**KIRKLEES METROPOLITAN COUNCIL
INVESTMENT & REGENERATION SERVICE**

Reference No: 2020/62/92782/W

Site Address: Huddersfield Lawn Tennis and Squash Club,
Cemetery Road, Edgerton, Huddersfield, HD1 5NF

Description: Erection of canopy to Padel courts

Title
Proposed layout and elevations.

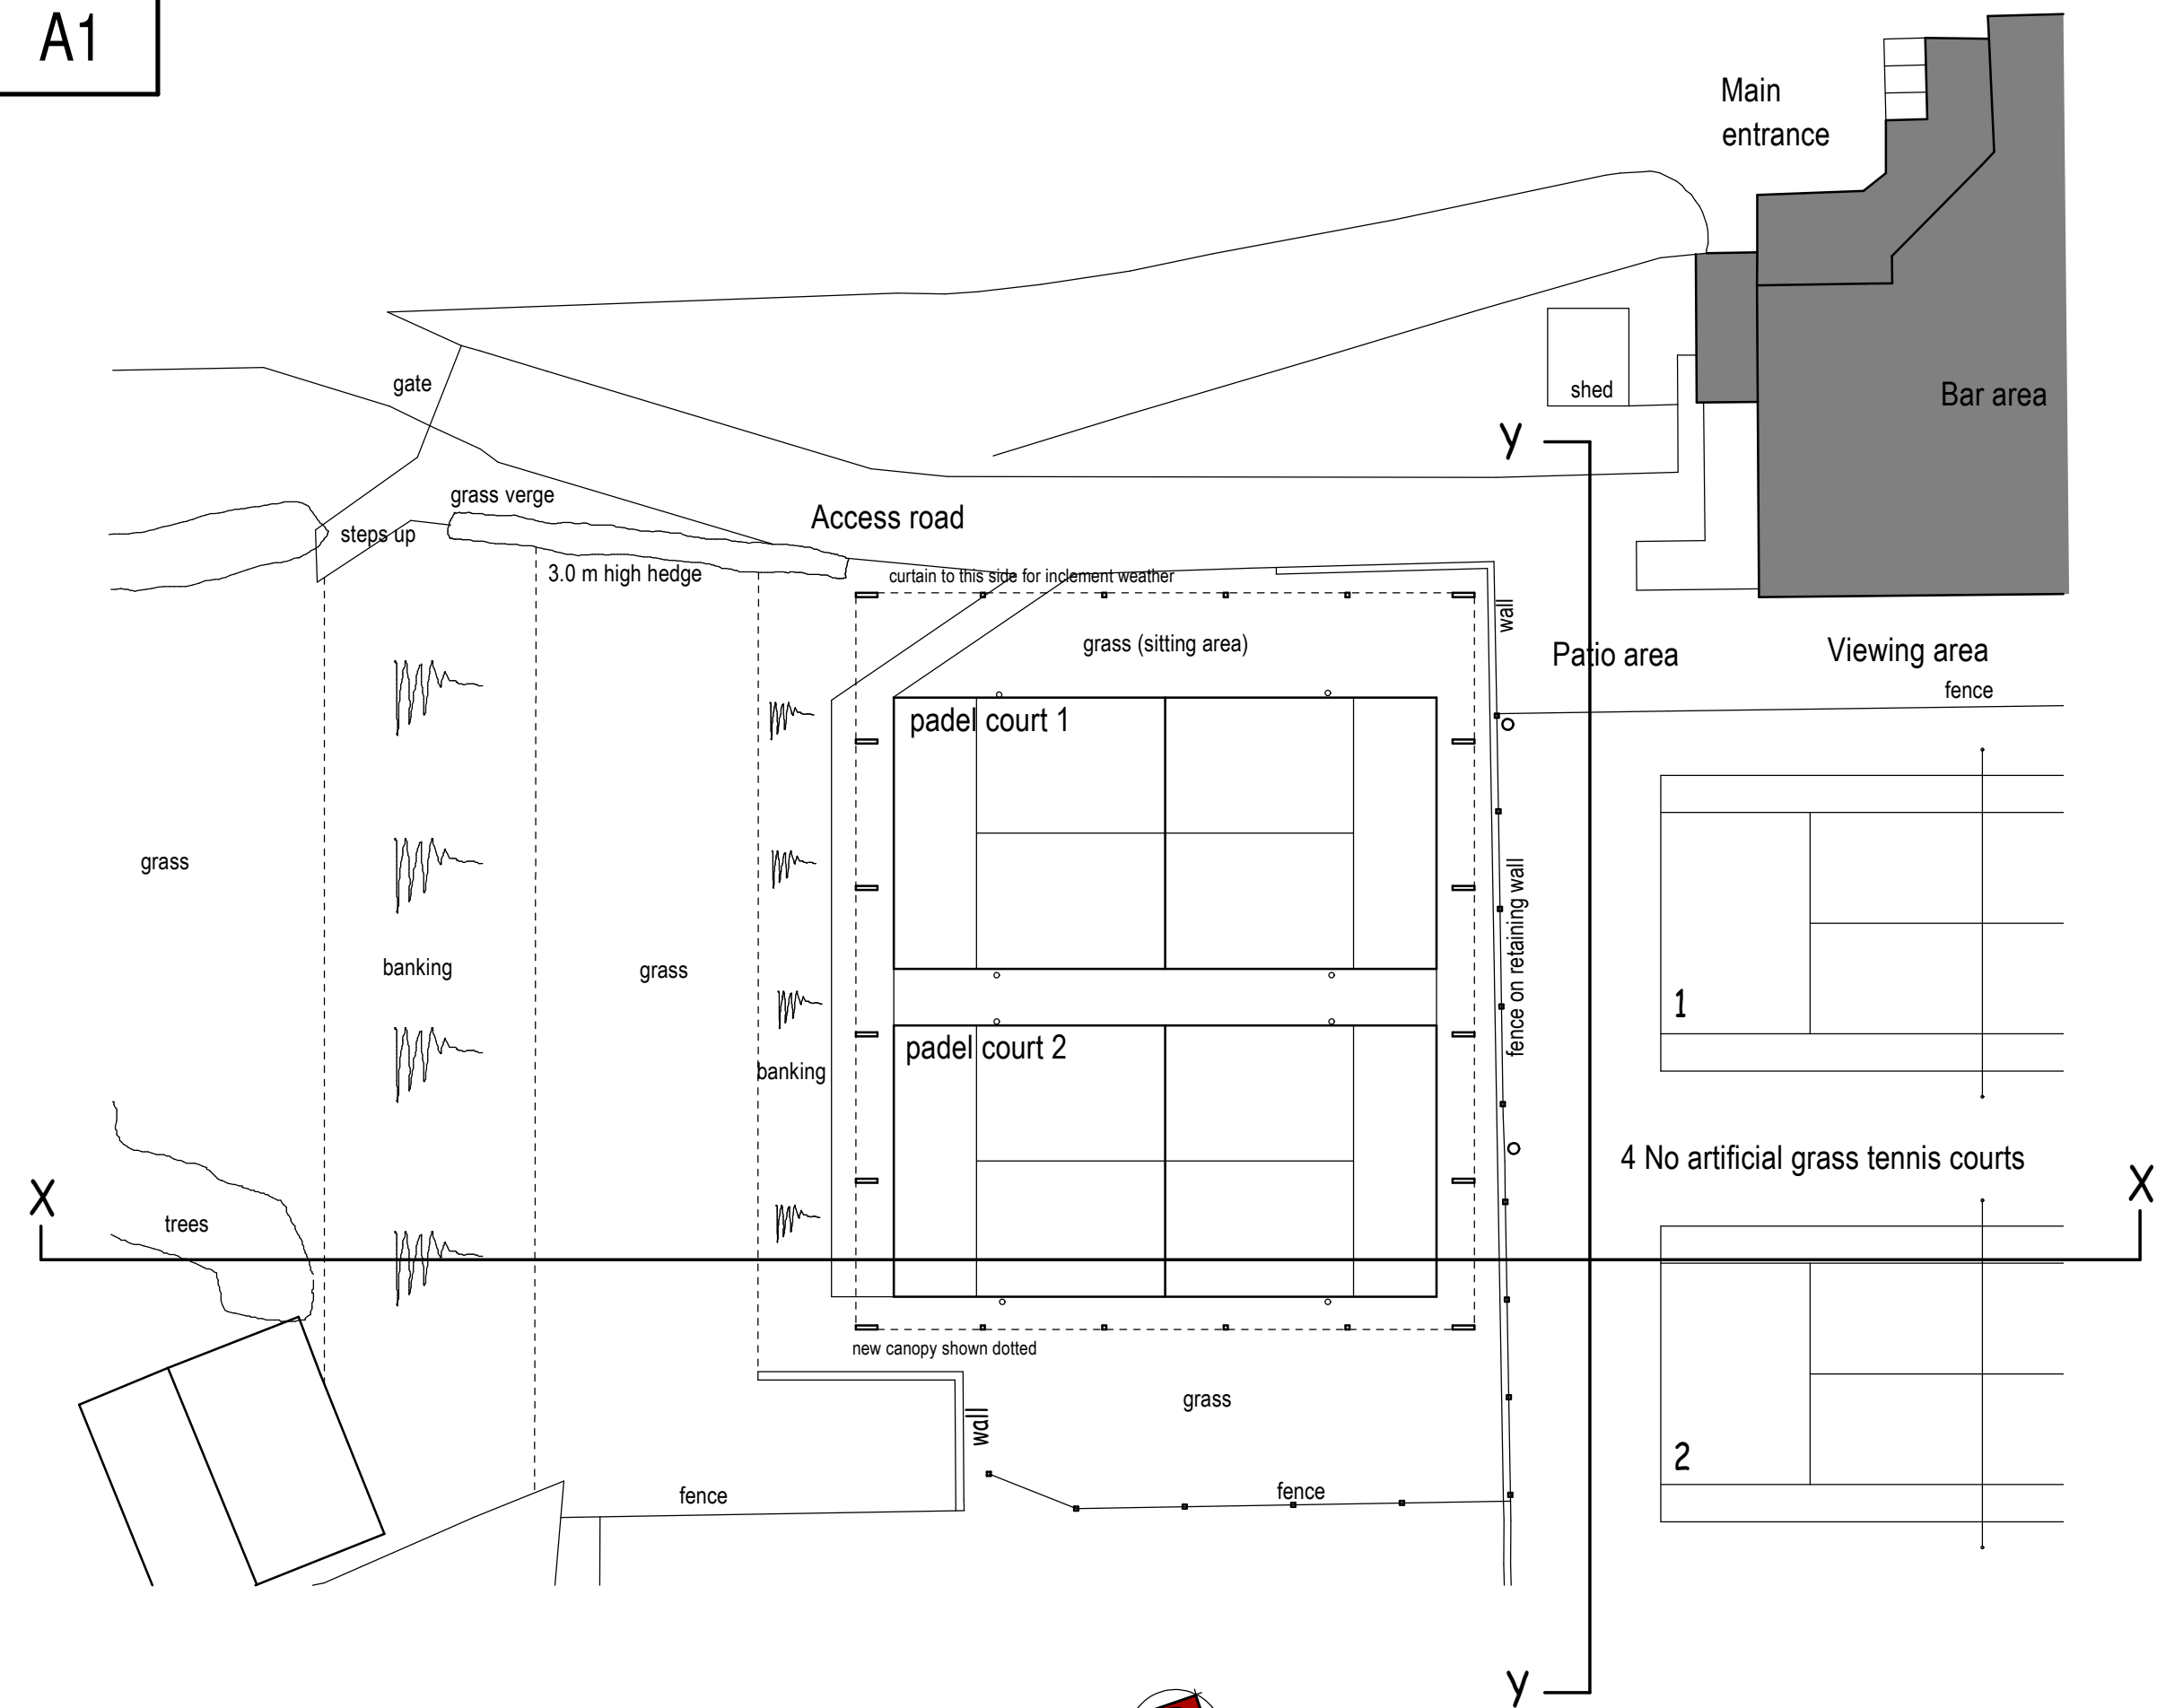
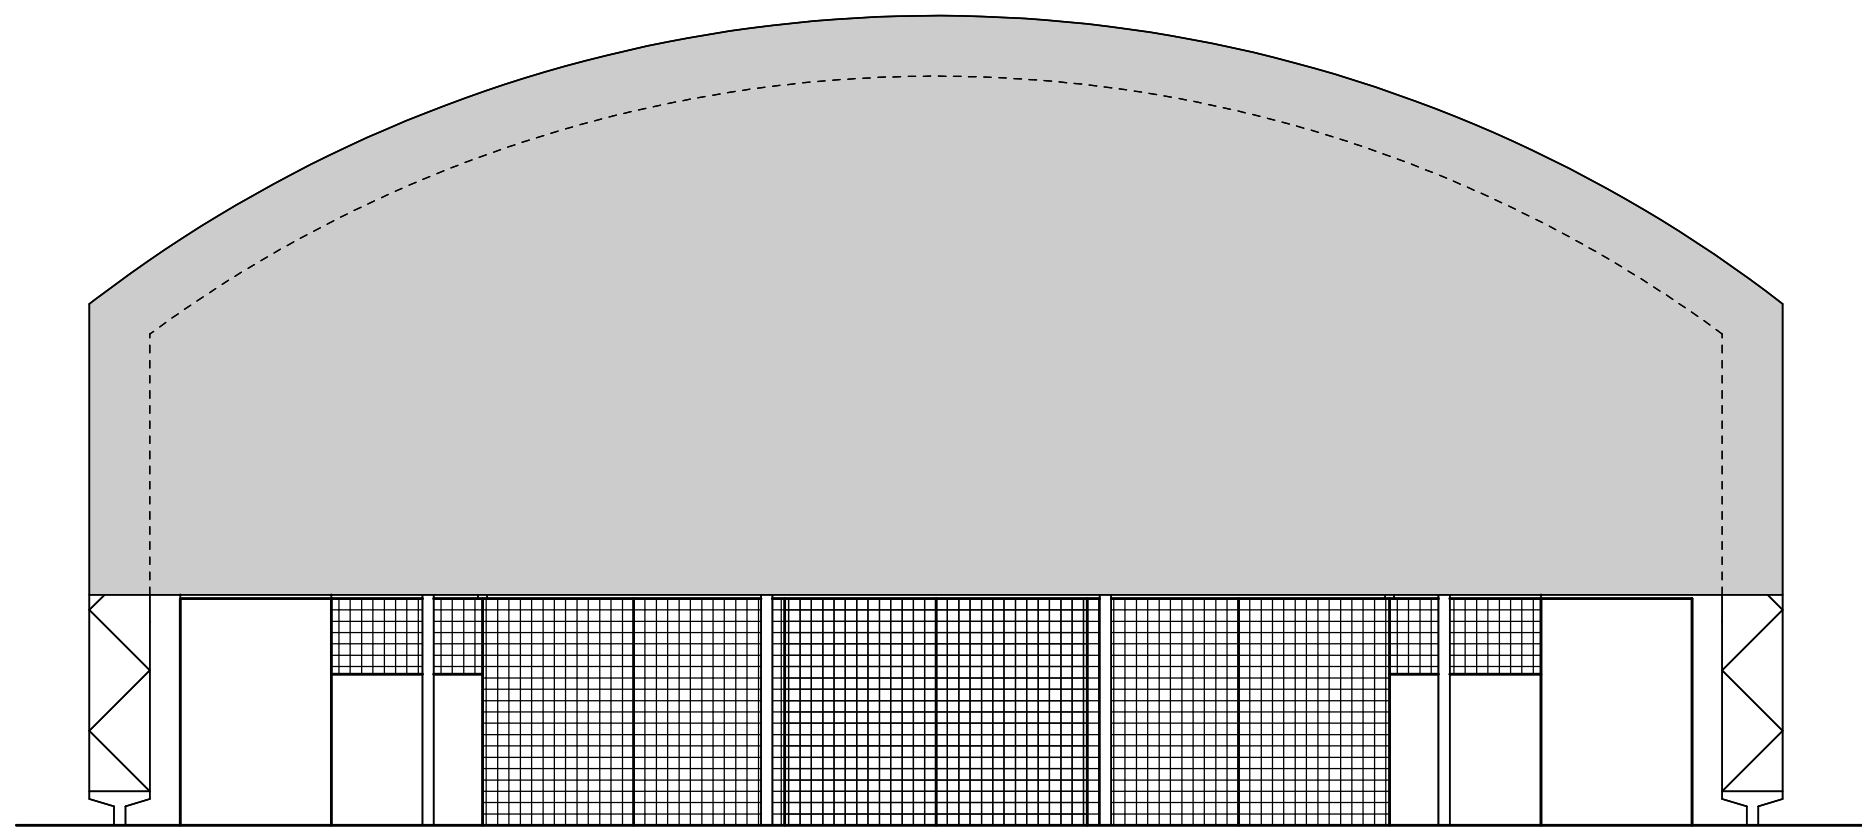
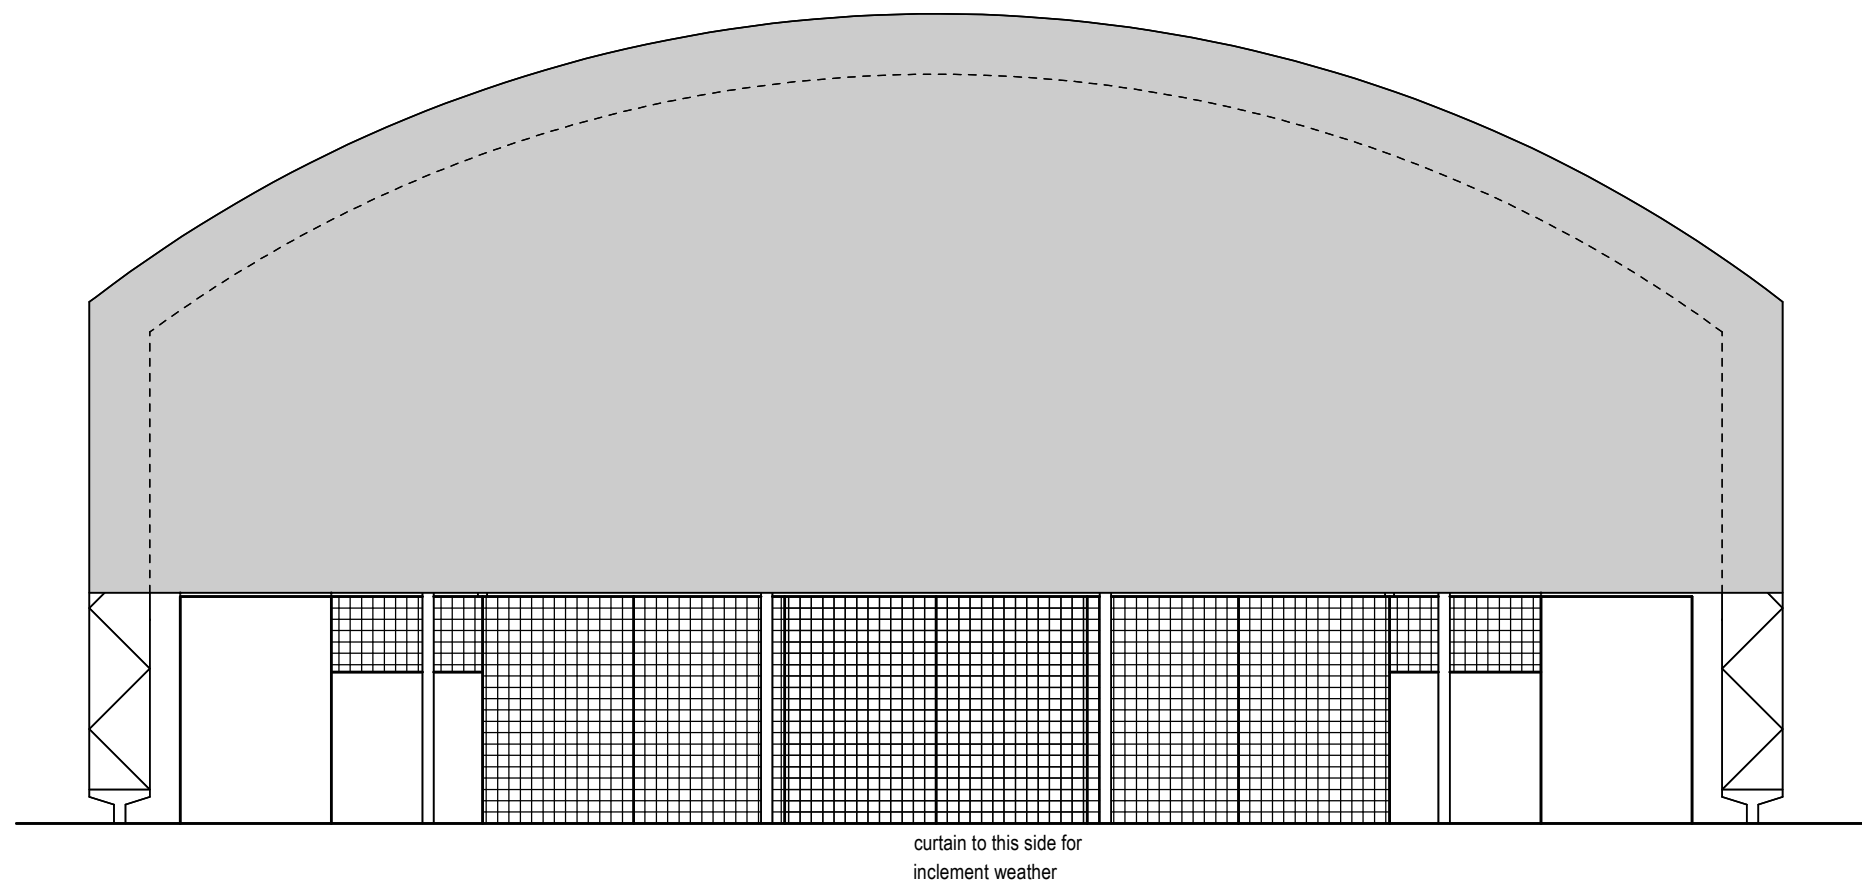
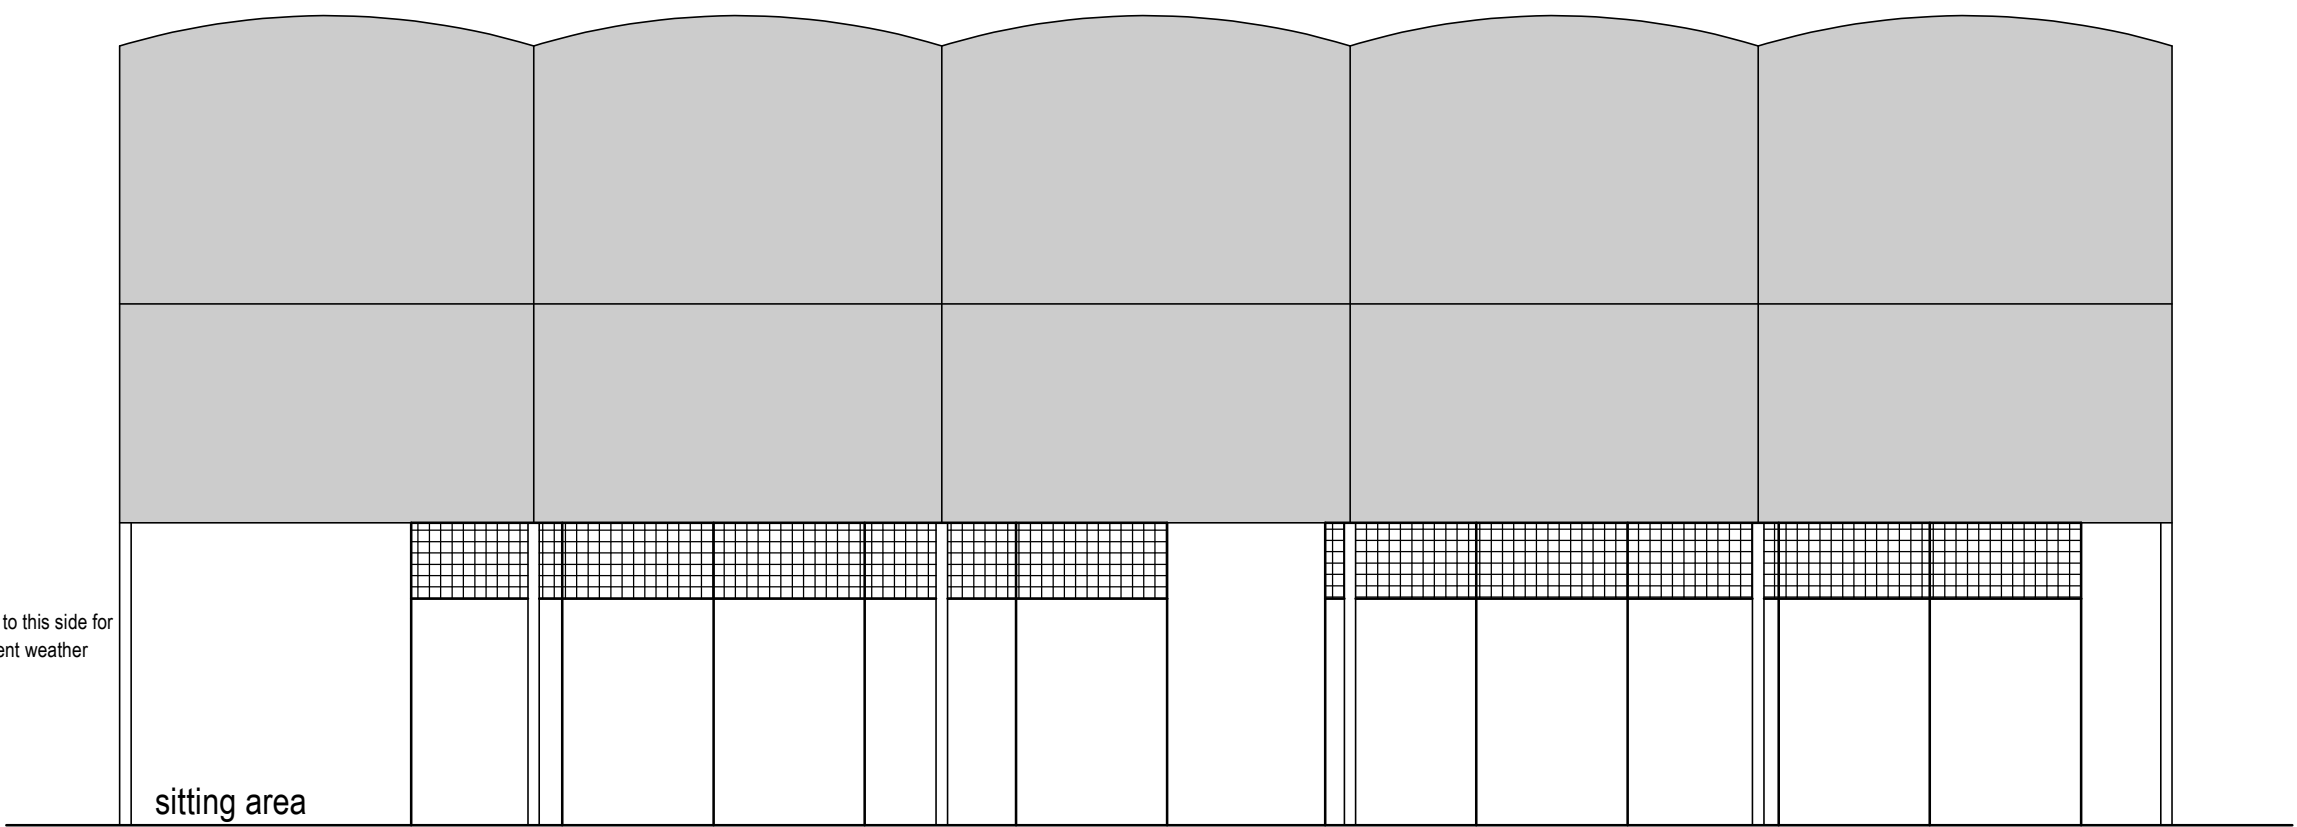
Justification was requested by officers for the proposed height of the canopy roof. The applicant's agent provided further detail relating this matter by e-mail on 9th October 2020 to address this issue. In addition, the applicant's agent agreed to a condition restricting the hours of use of the padel courts on 11th November 2020.

As noted by the Council's Conservation Officer, Paragraph 194 of the NPPF states any harm to, or loss of, the significance of a designated heritage assets should require clear and convincing justification. The Council's Conservation Officer has noted that there should be clear and convincing justification that the height of the proposed canopy is the minimum necessary.

On this matter, the applicant's agent was asked to provide further justification for the height of the building. The applicant's agent provided a booklet from the Lawn Tennis Association (who are the governing body for Padel Tennis) which specifies court dimensions. This document states that the recommended height for new build facilities is 8 metres. As the roof of the building is curved, parts of the roof would fall below this height. It is noted by the applicant's agent that the parts of the curved roof are above 8 metres height to allow for 'lob shots' which are noted as a common shot in the sport and officers see no reason to disagree with this. In addition, the roof would be a similar height to that on the existing indoor tennis building on the site. Officers are content with the justification provided for the height of the building.

The proposed building would be relatively high, being a maximum height of 10.7 metres and would be somewhat functional in its appearance. That said, despite its overall height, views would mainly be restricted to Cemetery Road, Edgerton Cemetery and New North Road given the topography of the area and existing built development in the area.

3. Padel courts 1 and 2 as displayed on Drawing No.2020 20 02A shall not be used outside the hours of 07:30 to 22.30 on Monday-Sunday (including Bank Holidays), unless otherwise agreed in writing by the Local Planning Authority. The floodlighting serving Padel courts 1 and 2 shall only be used when those courts are in use.
